Our reference: DOC16/125936-02

I refer to your letter dated 8 March 2016 requesting the Environment Protection Authority's (EPA) comments on the exhibition of State Significant Development Application SSD 6960 – Stage 1B Basement, Barangaroo South.

Attachment A
EPA Comments on State Significant Development Application SSD 6960 – Stage 1B Basement, Barangaroo South.

Figure 3 PM₁₀ cumulative concentrations ranked and plotted over the full modelling period

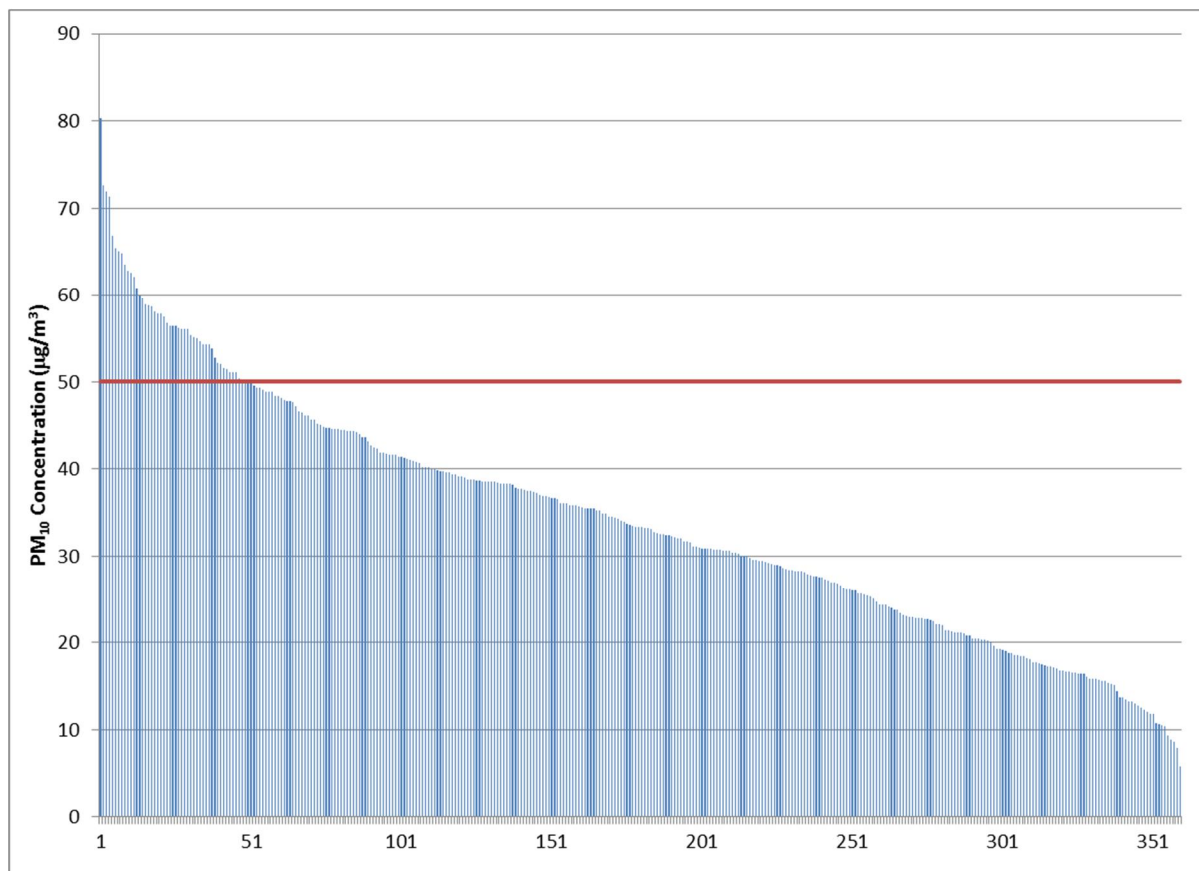
The AQIA does not include a detailed breakdown or analysis of the predicted exceedances, including the quantity and contributing factors. It is therefore difficult to comprehensively interpret the risk of adverse air quality impacts from the project. The AQIA also does not provide a discussion or assessment on potential alternatives, such as reduced excavation rates or activities with the aim of reducing particulate matter emissions to ensure exceedances do not occur.

The proponent should provide further analysis of predicted exceedances, including the quantity of predicted exceedances, the contributing factors and an options analysis.
